Subject: Land south of Barnham Station Barnham - BN/142/20/OUT

Planning Application reference: BN/142/20/OUT

Address: Land south of Barnham Station Barnham

Craig Milligan
Environmental Health Officer
Technical Services

FIGURE 43. Density strategy plan

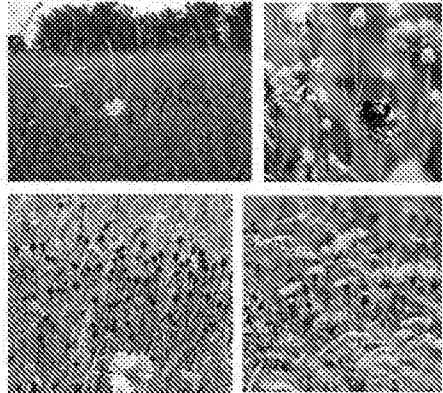
The good acoustic design of the development shall include high density housing to be located along the western boundary of the site to provide an acoustic barrier for the rest of the development, as detailed on page 86 of the document titled 'Land South of Barnham Station, Barnham: Design and Access Statement'.
